# CITY OF ALBUQUERQUE

**Re: Santa Fe 3 (new) at the Trails Unit II (Tract 4) Grading and Drainage Plan  
Engineer's Stamp dated 10-13-06 (C9/D1D)**

CITY OF ALBUQUERQUE PUBLIC WORKS DEPARTMENT ENGINEERING GROUP			
SANTA FE 3 AT THE TRAILS UNIT II GRADING & DRAINAGE PLAN			
Design Review Committee	City Engineer Approval	Last Design Update	Mo./Day/Yr.
City Project No. 730087	Zone Map No. C-9-Z	Sheet 3	Of 3

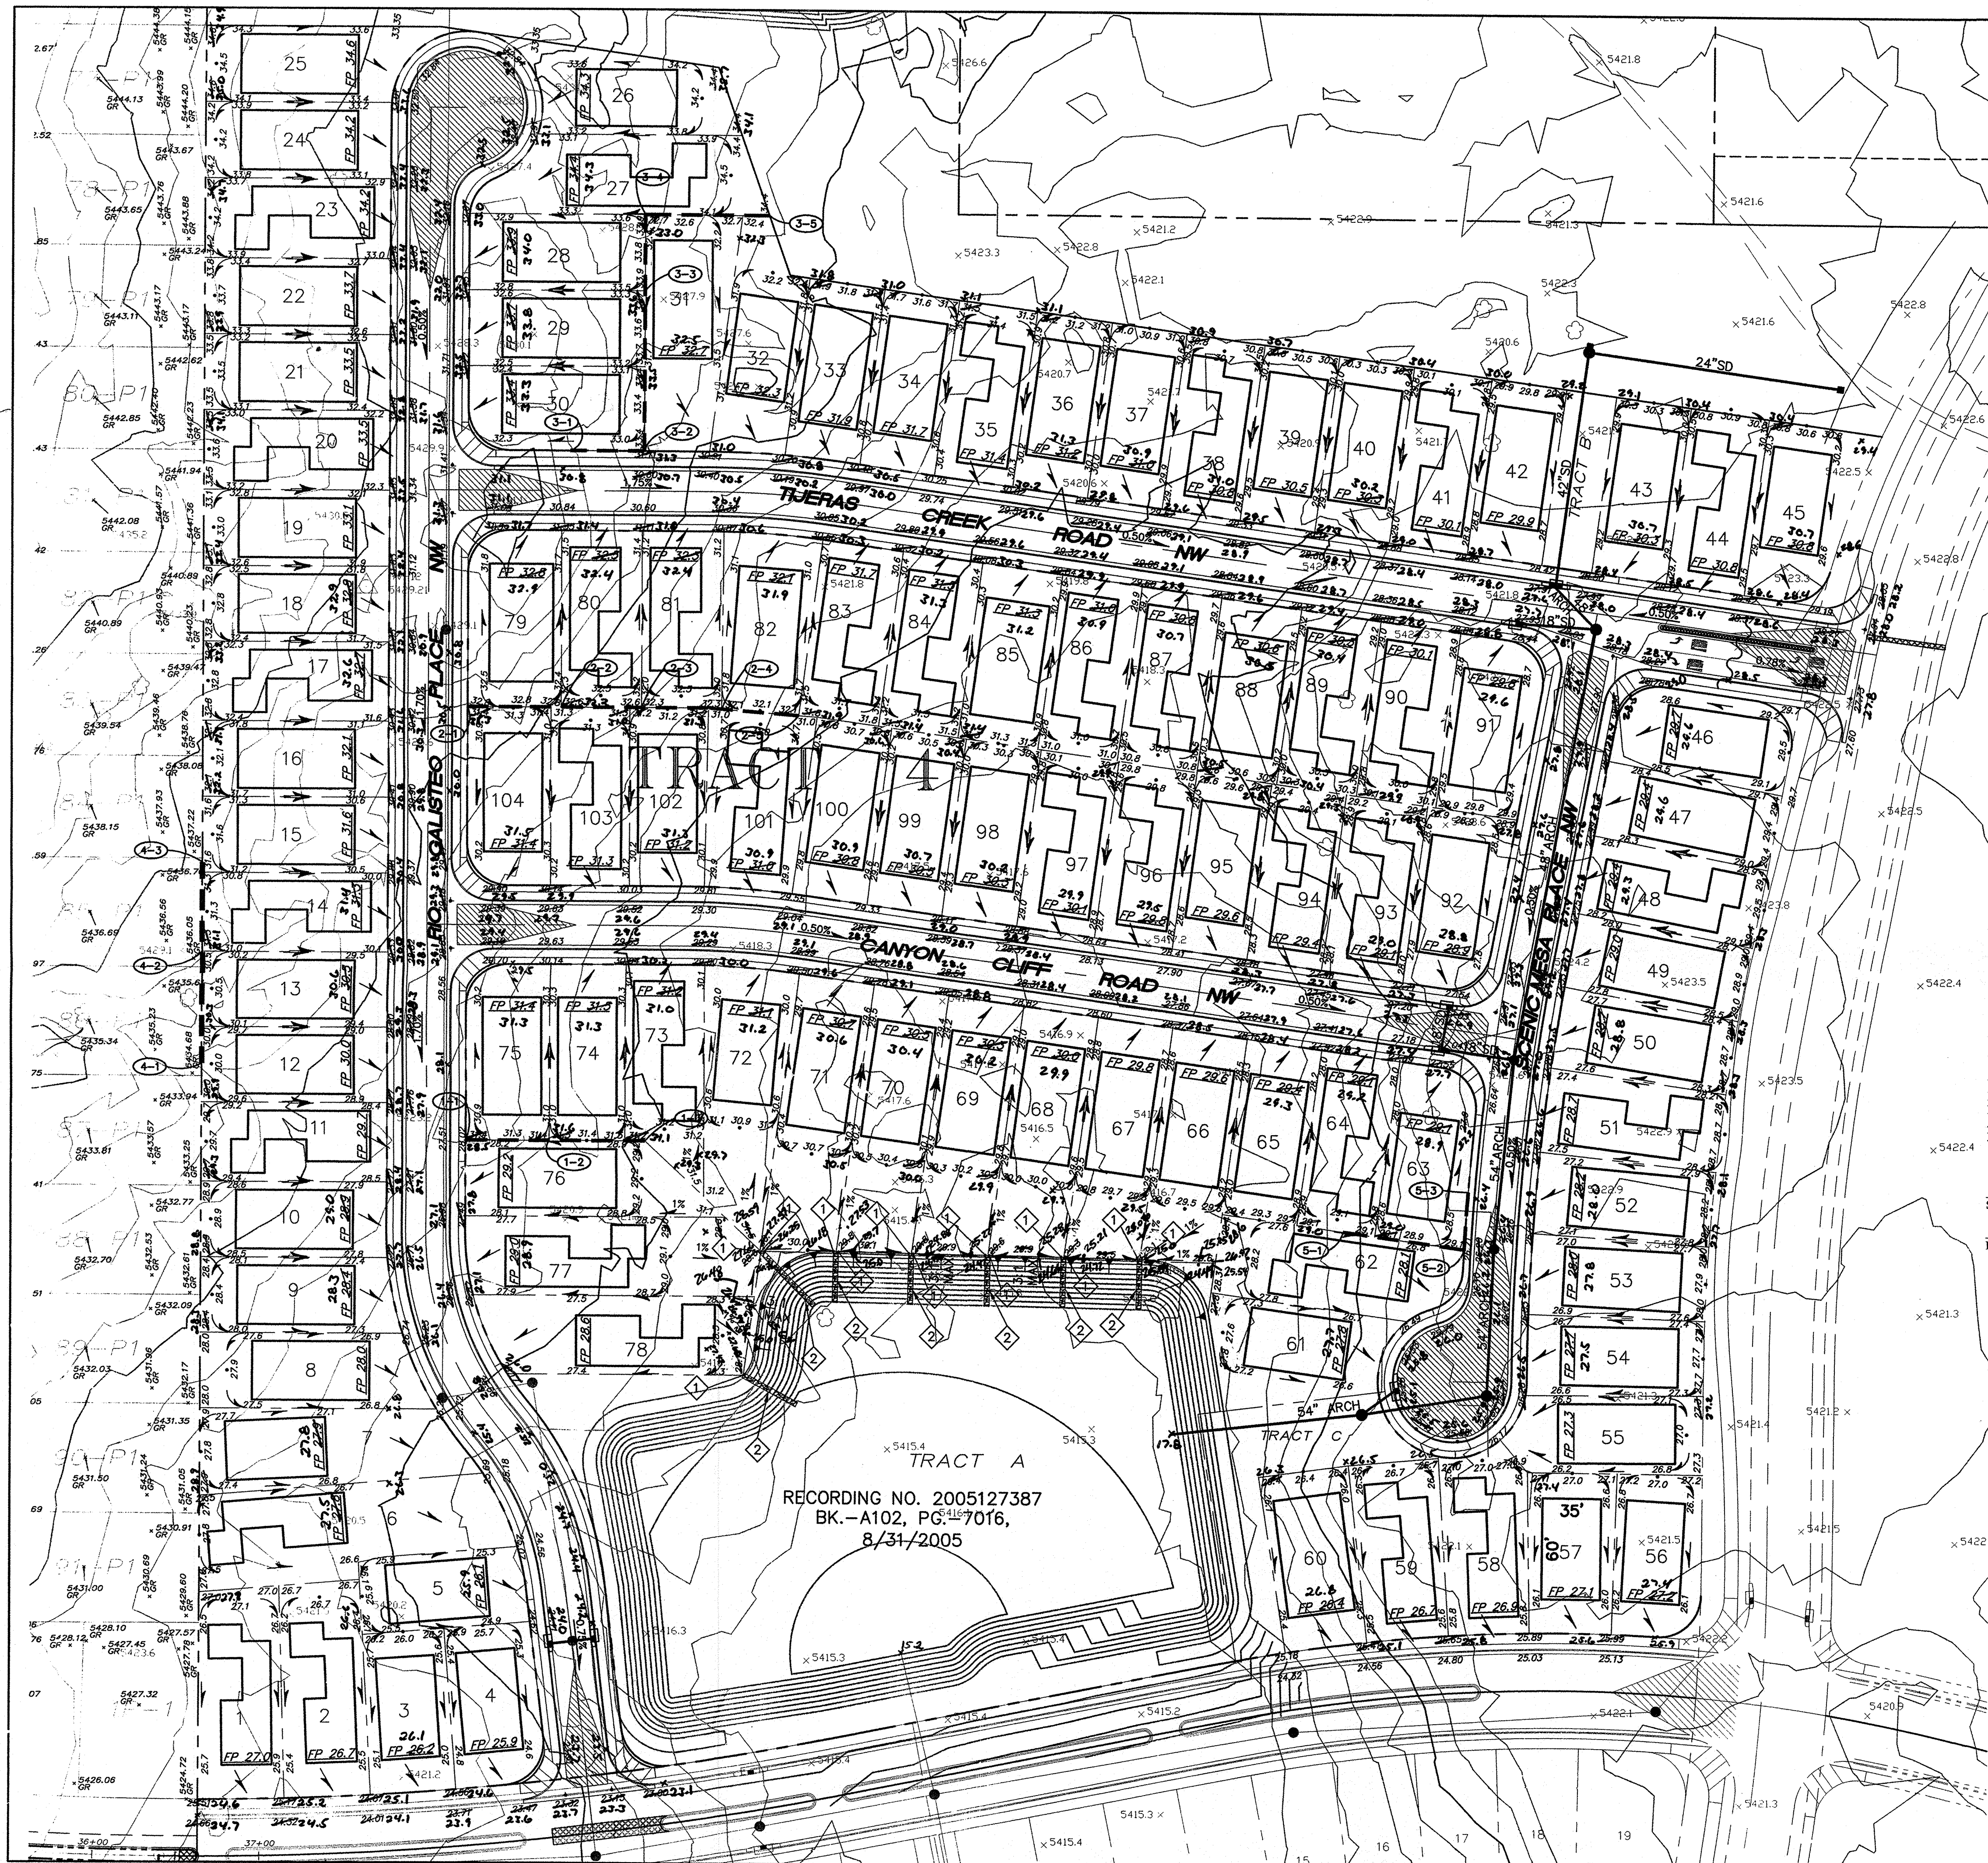
This submittal has more dwelling units per acre than the previous submittal for this project, which increases the amount of impervious area and therefore the runoff. Provide the calculations for the increase in runoff and whether pond F/system is still adequate. Also, provide street capacity calculations.
